From: Sarah Burrow [REDACTED]
Sent: 04 June 2020 07:58
To: Planning.Responses <Planning.Responses@arun.gov.uk>
Cc: Andrew Wood [REDACTED]
Subject: RE: Planning Consultation on: F/2/20/PL

Engineers Comments Regarding Surface Water Drainage

APPLICATION NO: F/2/20/PL

Description of Works: Change the use of 1/2 the site area to a hard standing storage area
(resubmission following F/9/19/PL).

Proposed Fence and earth mound elevation

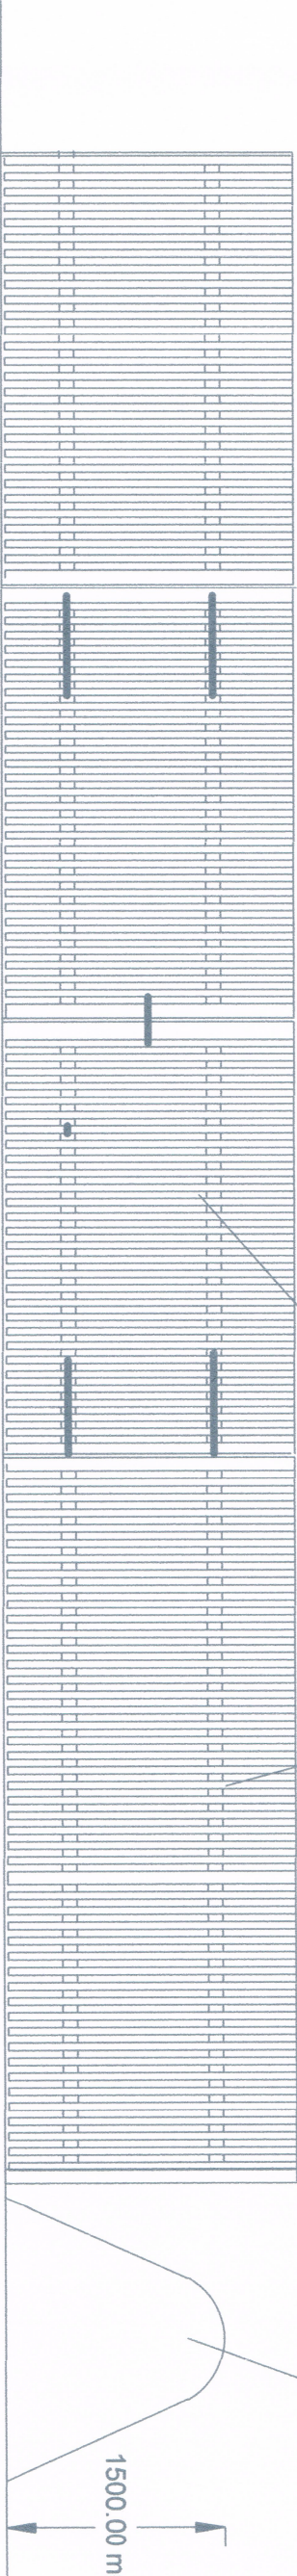
1. Does the applicant intend to raise ground levels on the site? (Aside from the bunds)
2. One location plan (06/02/2020) shows a bund and ditch being formed in part of the site, outside the red line shown on the Site Area Plan. Do these form part of this application?
3. Little detail is given of the construction of the permeable paving, it is claimed to be permeable, but the application form mentions a mot type 2 finish which is not permeable once compacted.
